**Application Number:** 6/2021/0181/MAJ

**Location:** Former Shredded Wheat Factory, Broadwater Road, Welwyn Garden City, AL7 1RR

Thank you for consulting the Twentieth Century Society on the proposals for the above building. While the Society does not object to the application outright, it does wish to articulate concerns relating to the replacement of the windows in both the Production Hall and the Grain House and Silos.

Project	Shredded Wheat Factory
Subject	P2 Proposed First Floor
Scale	1:100 @ A1   1:200 @ A3
Original Size	A1
Date	29 10 2018
Drawing No.	332_3a_102_F

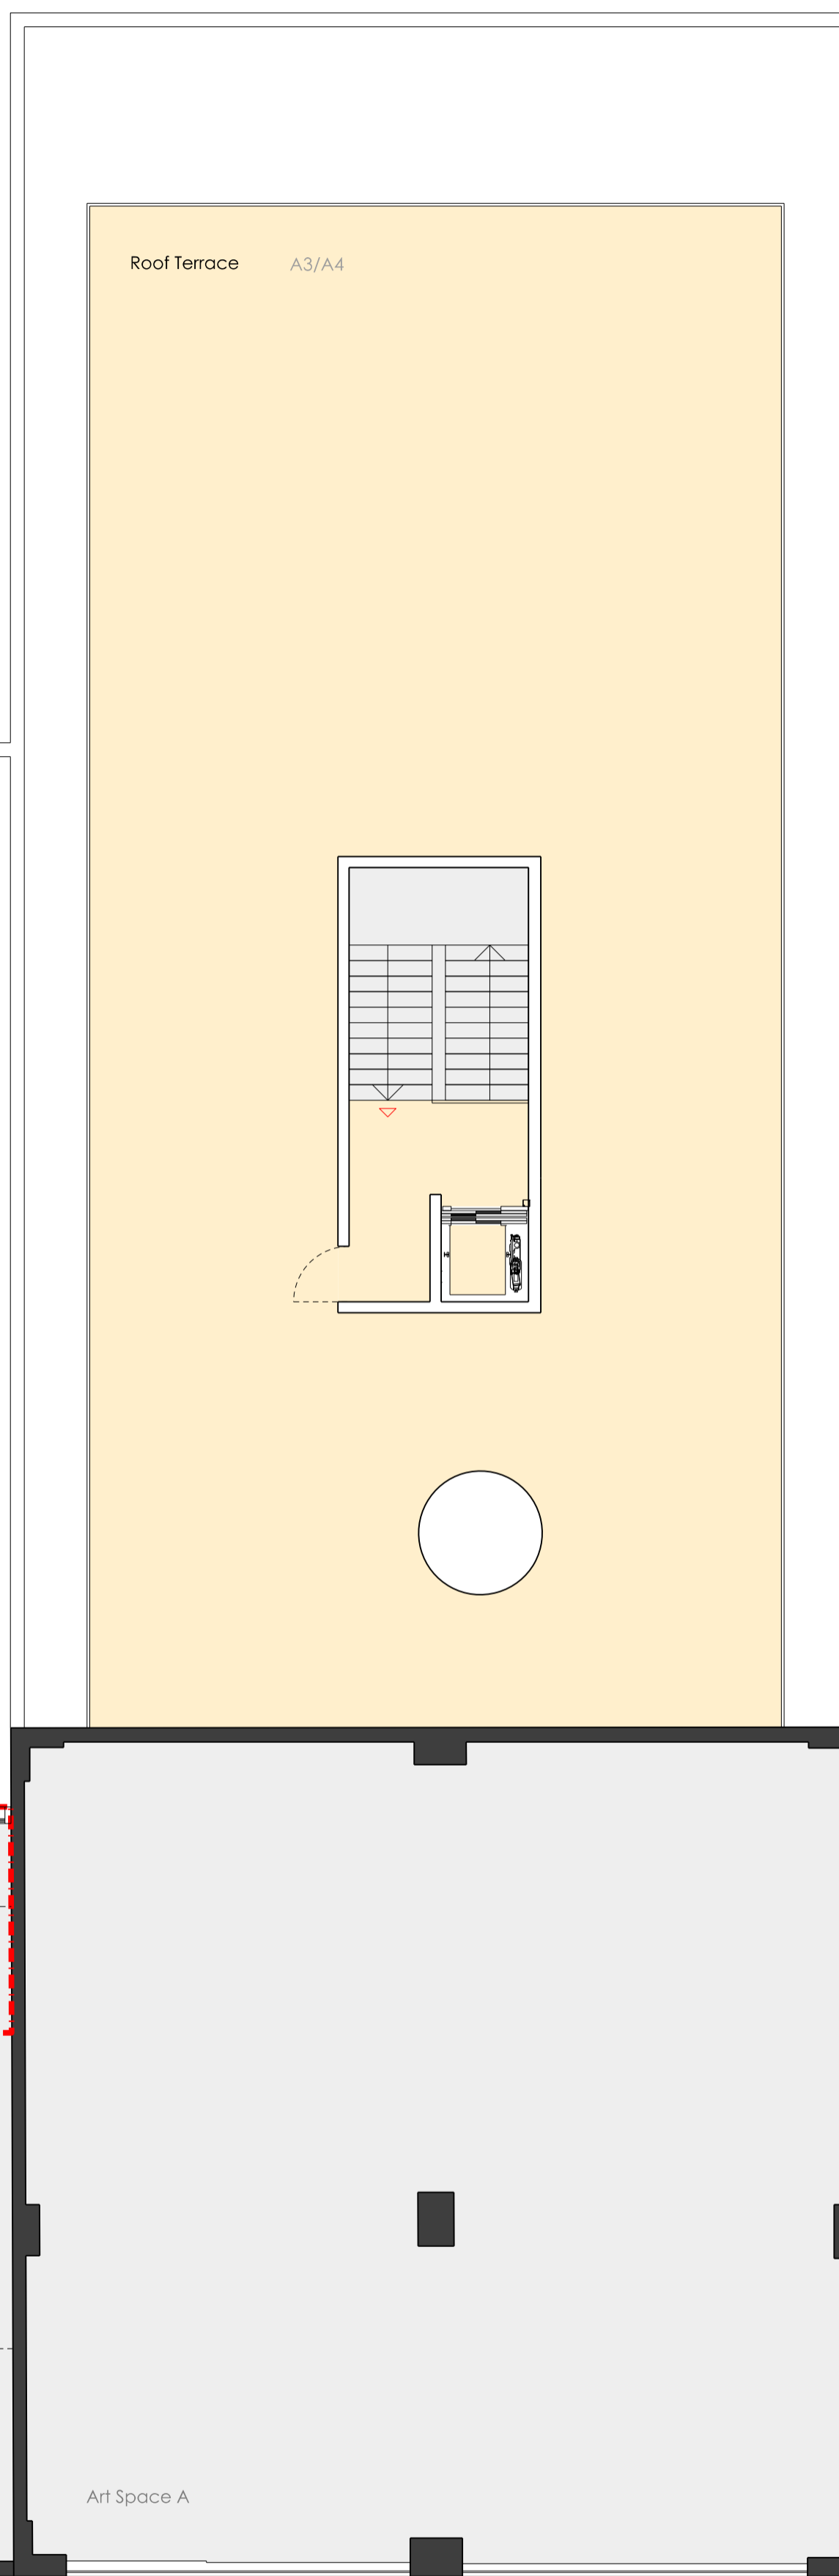
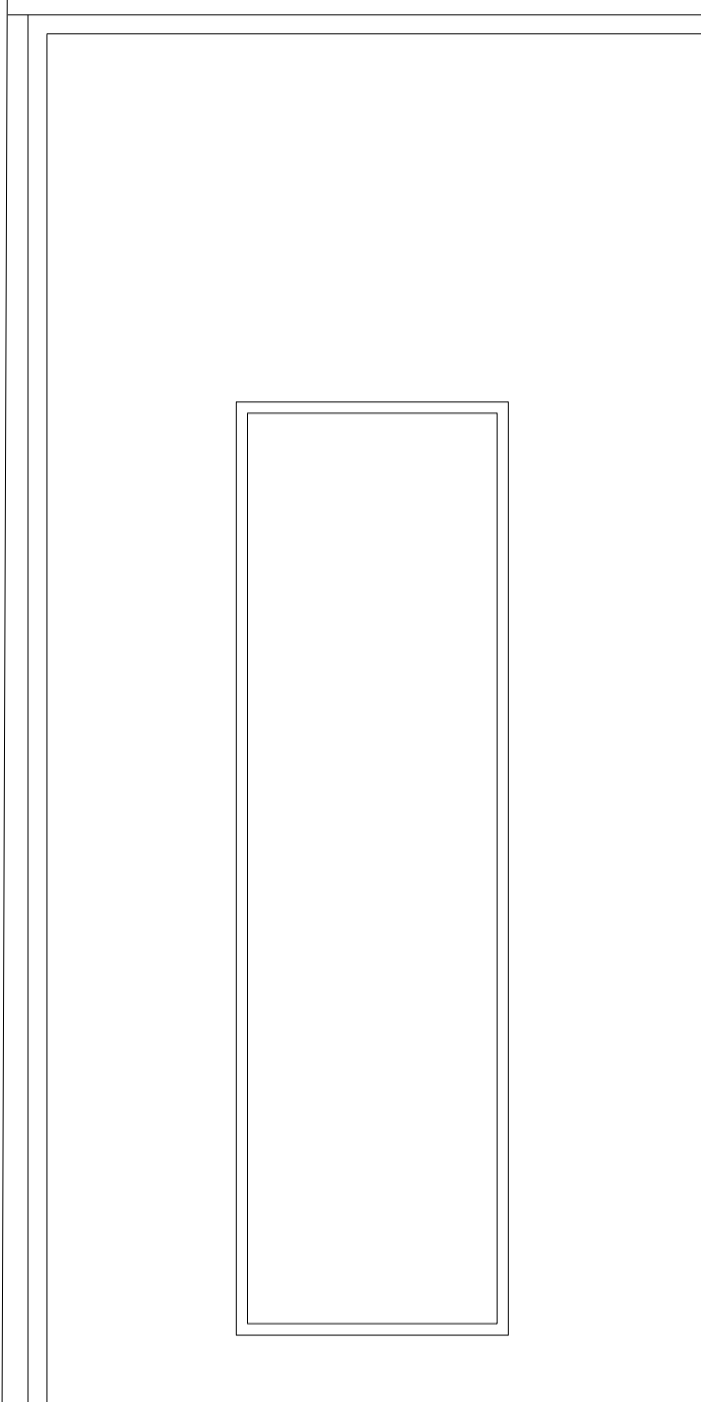
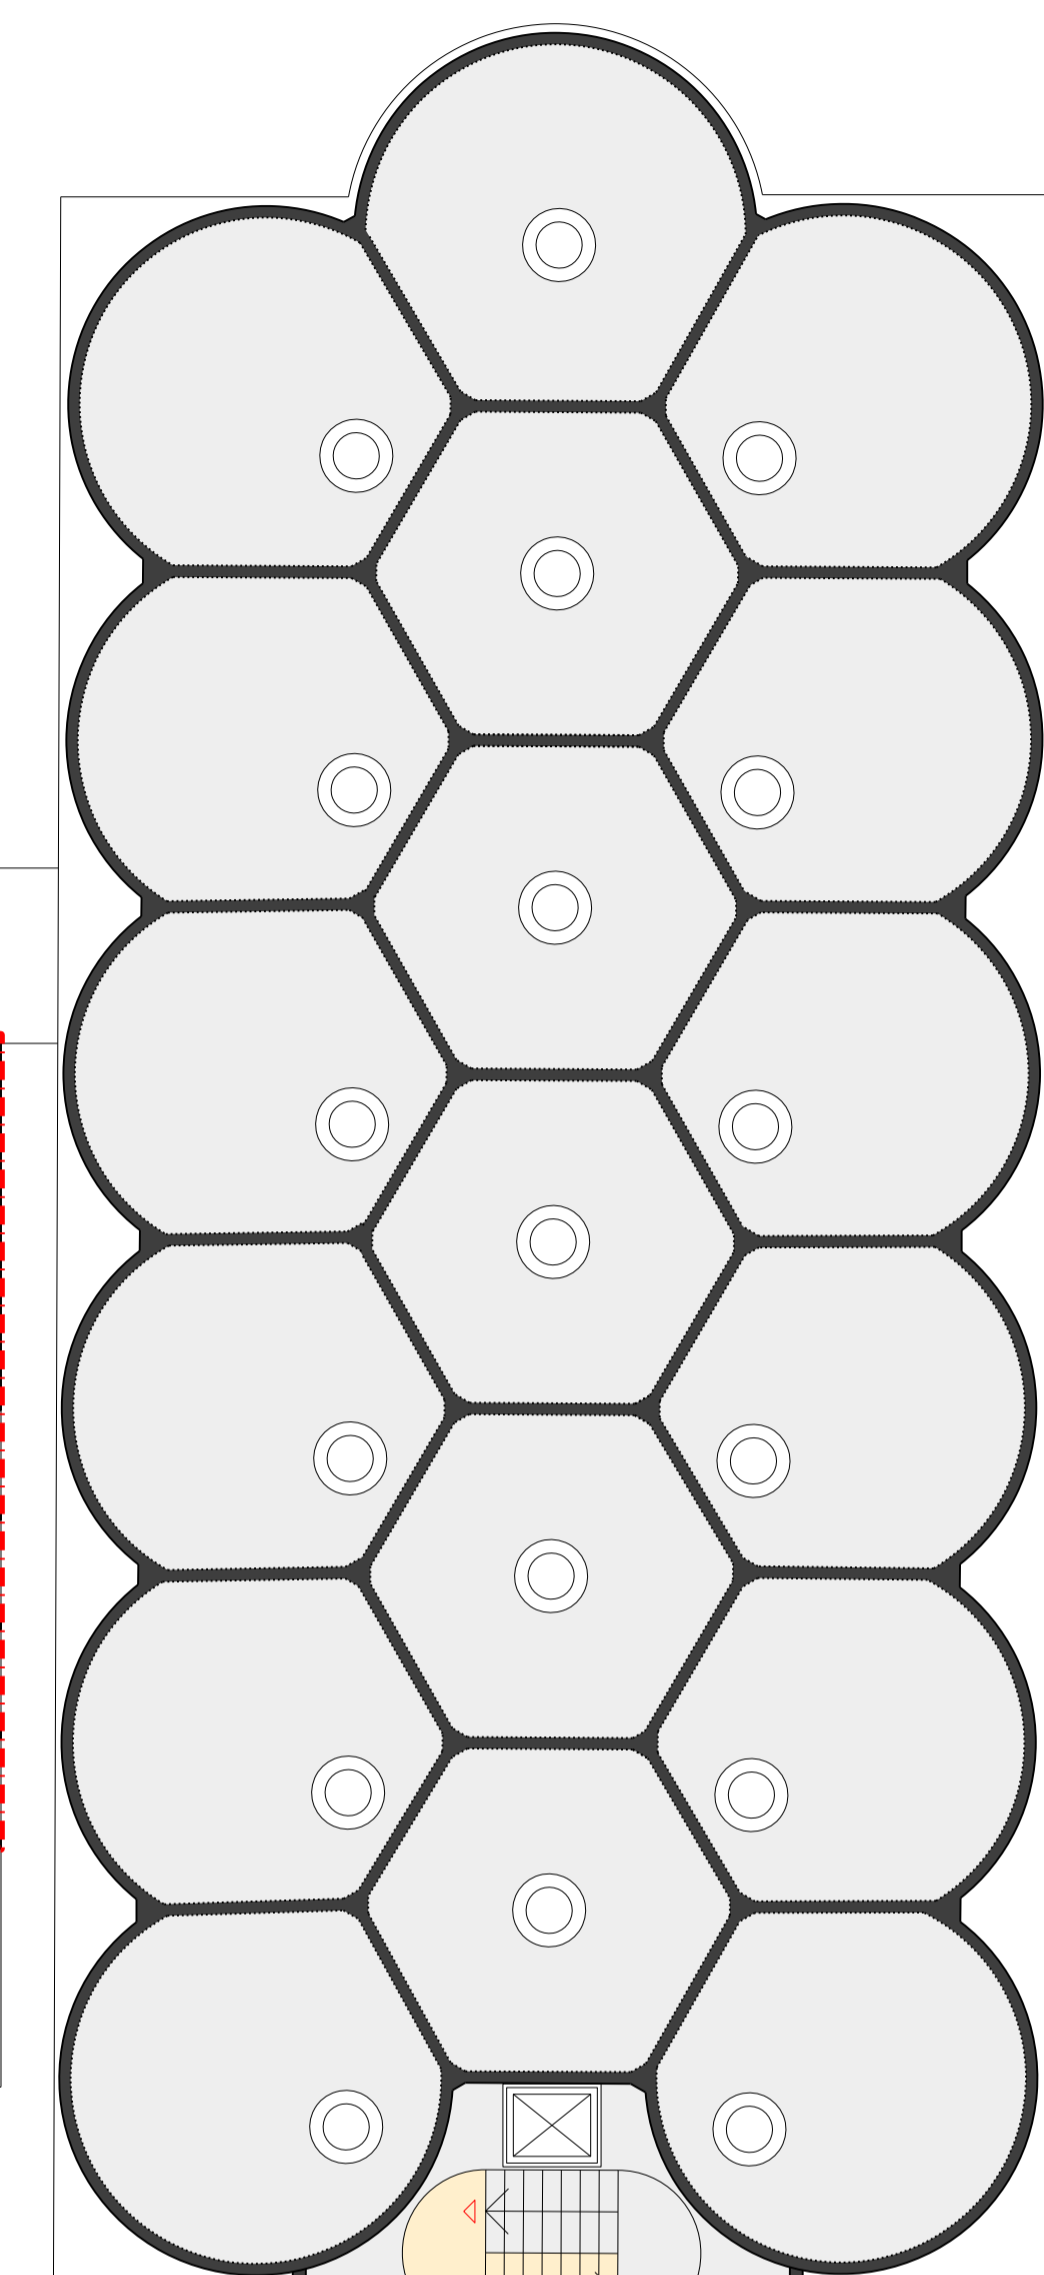
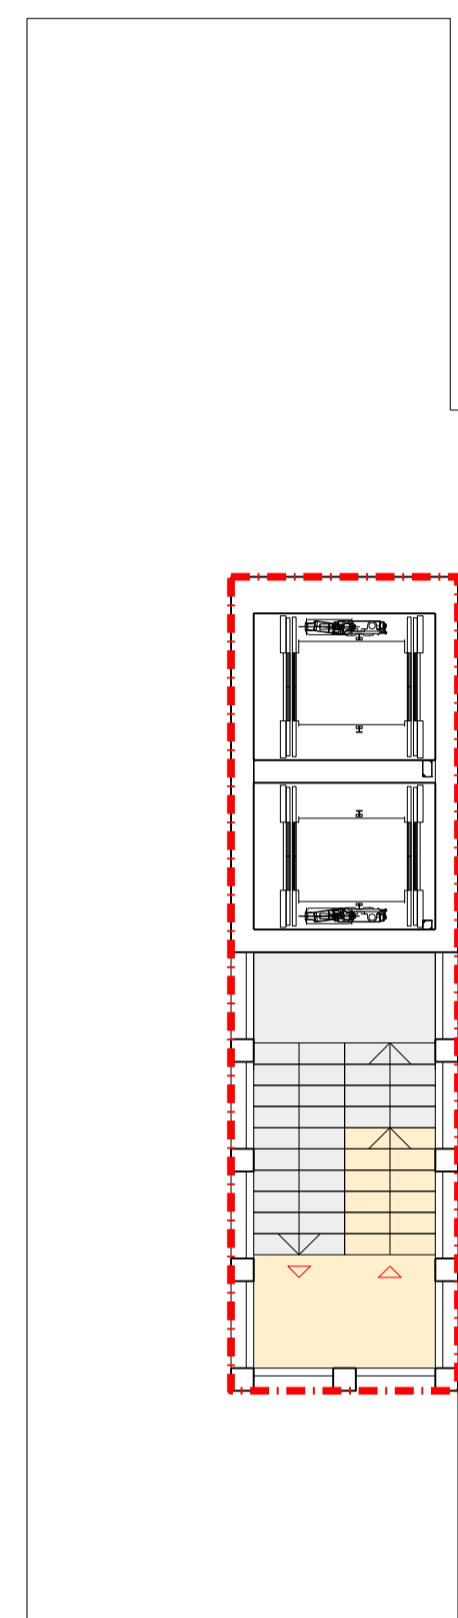
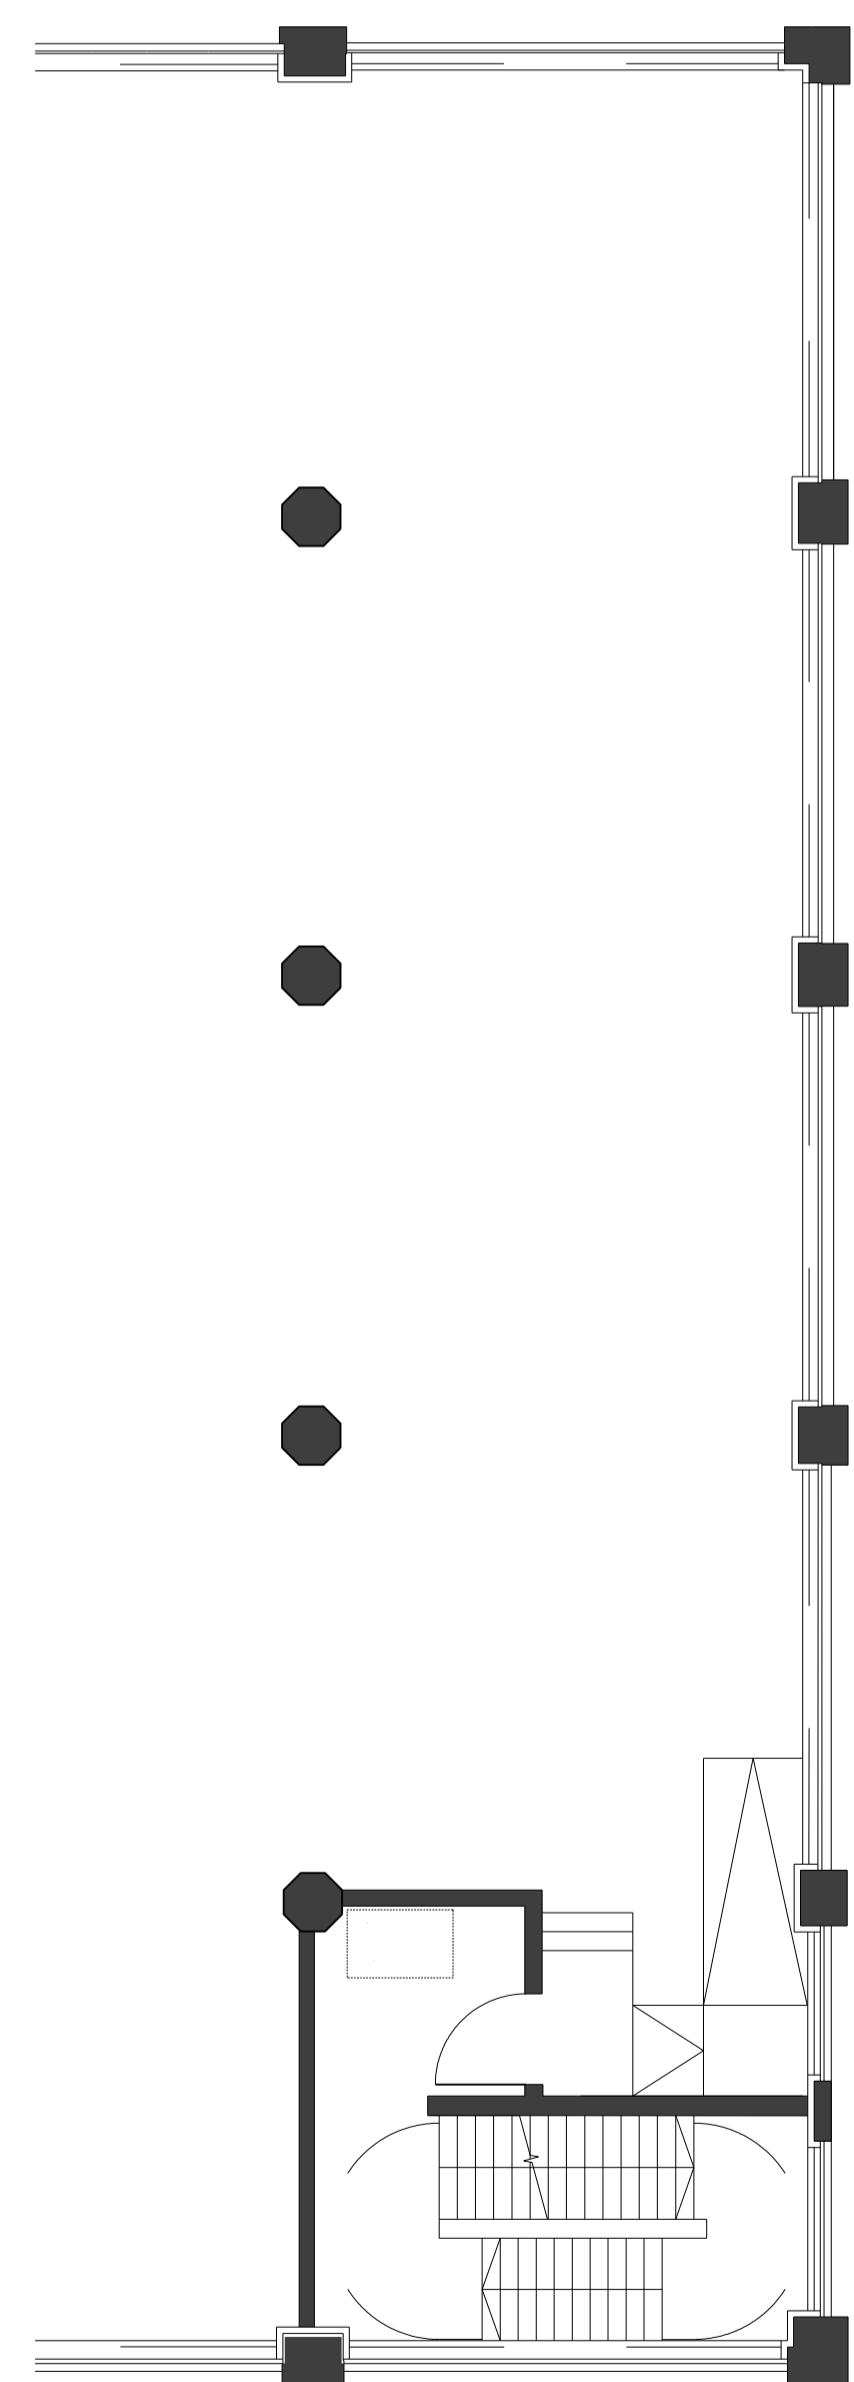
However, the Society would note that the fenestration plans regarding both the factory buildings require careful attention and modification. We believe that the primary windows should be retained in order to best preserve the original vision of de Soissons. Where windows have been replaced with UPVC units or openings bricked up, windows in the style of the originals should be installed. Where primary windows are still in place, these should be retained and repaired.

Furthermore, the Society is concerned about the proposed windows for the restaurant of the Grain House and Silos- particularly through Jamie Fobert Architects' proposed use of 'floor-to-ceiling height fins and glazing panels'. We note that the added window space necessitates the undesirable removal of the original green metal on the top floor.

In conclusion, the Society reiterates that the windows are repaired rather than removed, and, if necessary, secondary glazing installed to improve their thermal performance. We therefore advise the applicants to revise the scheme to retain the original windows.
